KITTITAS COUNTY COMMUNITY DEVELOPMENT SERVICES

October 17, 2025

RE: Sedgwick Short Plat Final (SPF-25-00005) – Staff Review and Request for Final Mylars

SP-24-00012
SPF-25-000?

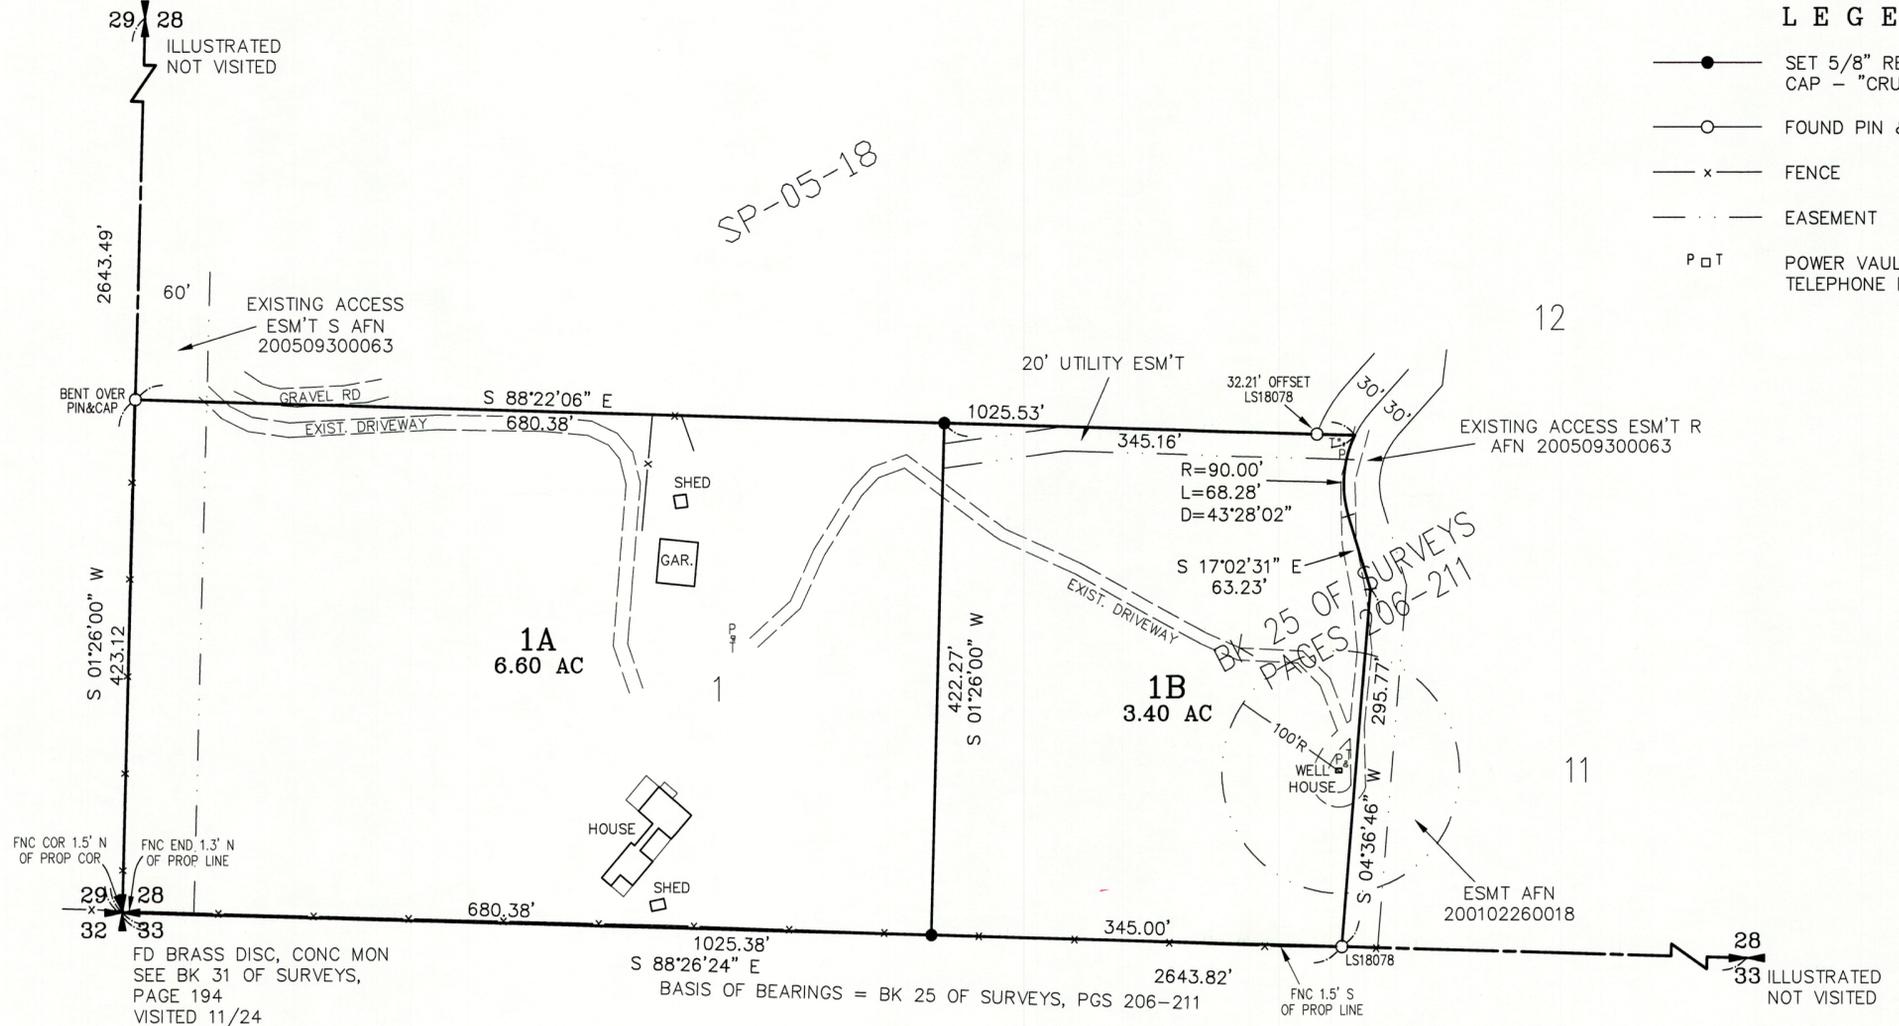
- “SPF-25-00005 Sedgwick” must appear on the face of each mylar sheet along with the Preliminary Short Plat project number “SP-24-00012 Sedgwick.”

- Please ensure the new parcels created in this Short Plat are identified with correct addresses upon final recording.
